FULL

Reference: H02-1202-19 **Date of Decision:** 7th February 2020
Applicant: Postland Developments Ltd
Poplar Farm
Wisbech Road
Coates
Peterborough Cambs
PE7 2DU
Location: Land Between: 44-46 Postland Road Postland Road Crowland
Description: Proposed chalet bungalow and double garage

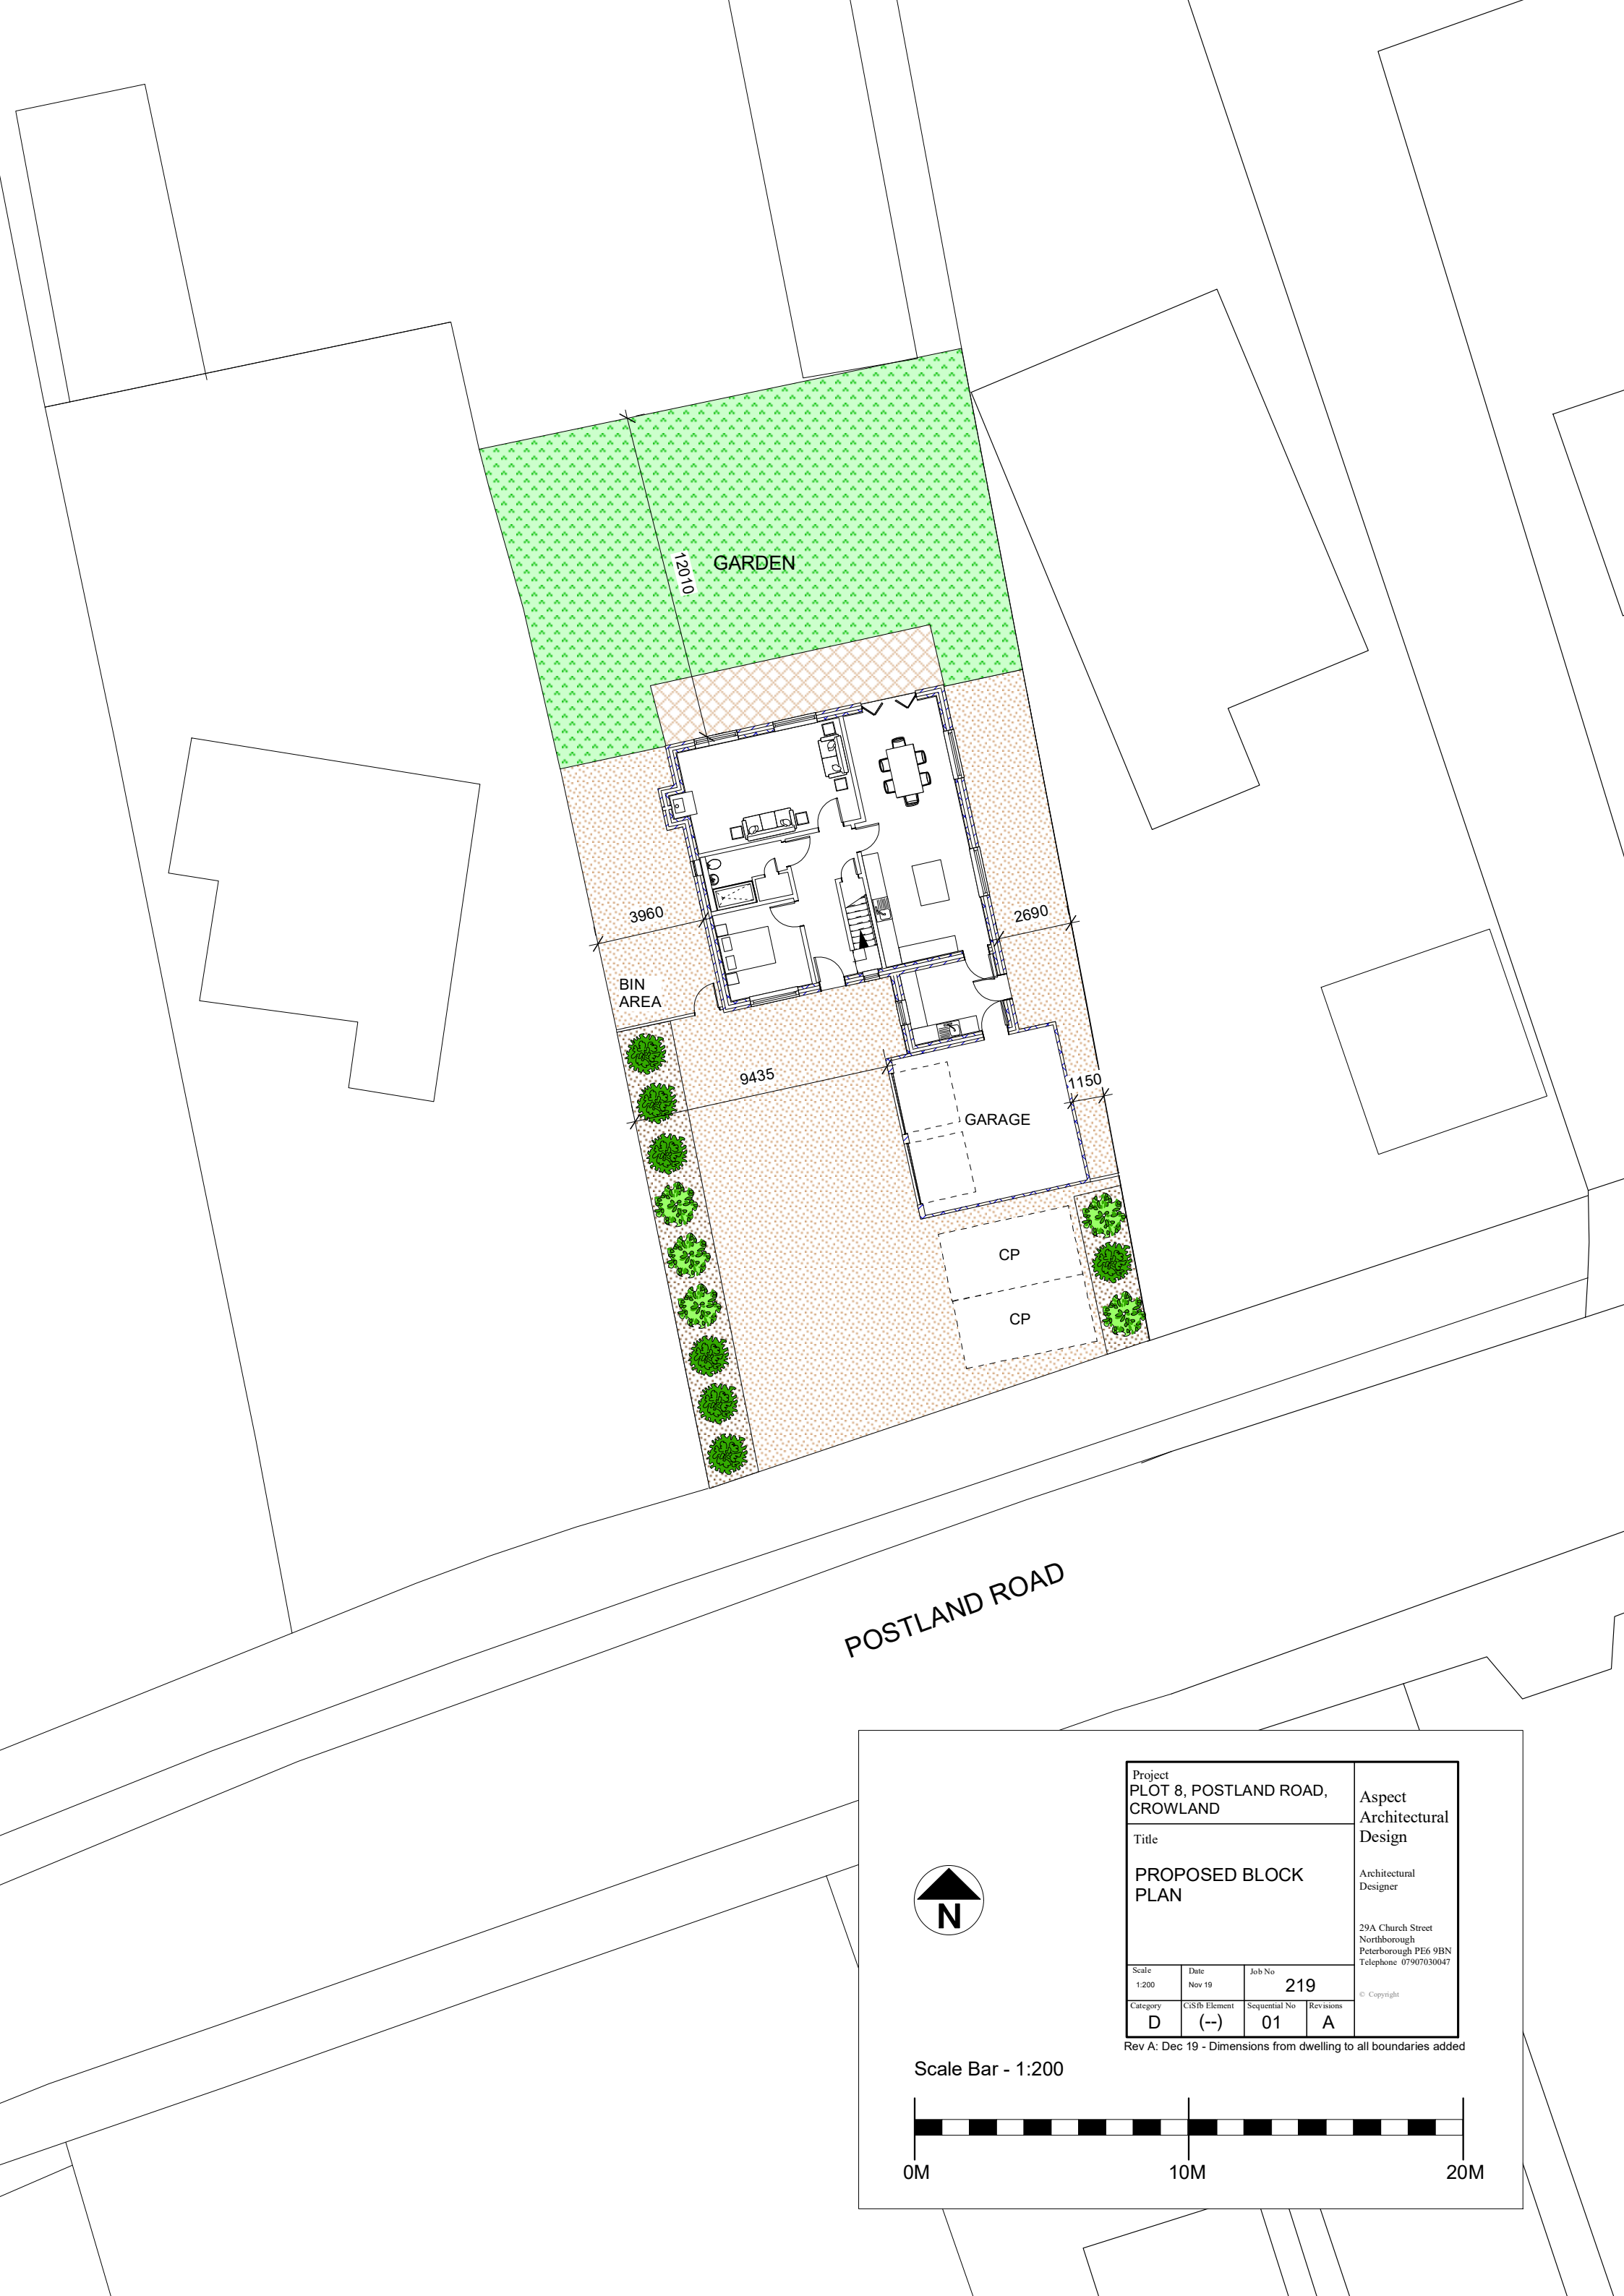
The submitted Block Plan indicates that the vehicular access to the proposed development would be on the west side of the plot's frontage to Postland Road. There appears to be an overhead electricity supply pole on the west side of the frontage and care will need to be taken to avoid the risk of accidental vehicle collision with this pole.

Also, the carriageway of Postland Road at the frontage of the site is drained by means of kerb offlets. There is a kerb offlet where it is indicated the access would be formed so suitable arrangements will need to be made to either relocate this kerb offlet and connect it to the existing outfall or provide a new road gully so that surface water does not collect in this area.
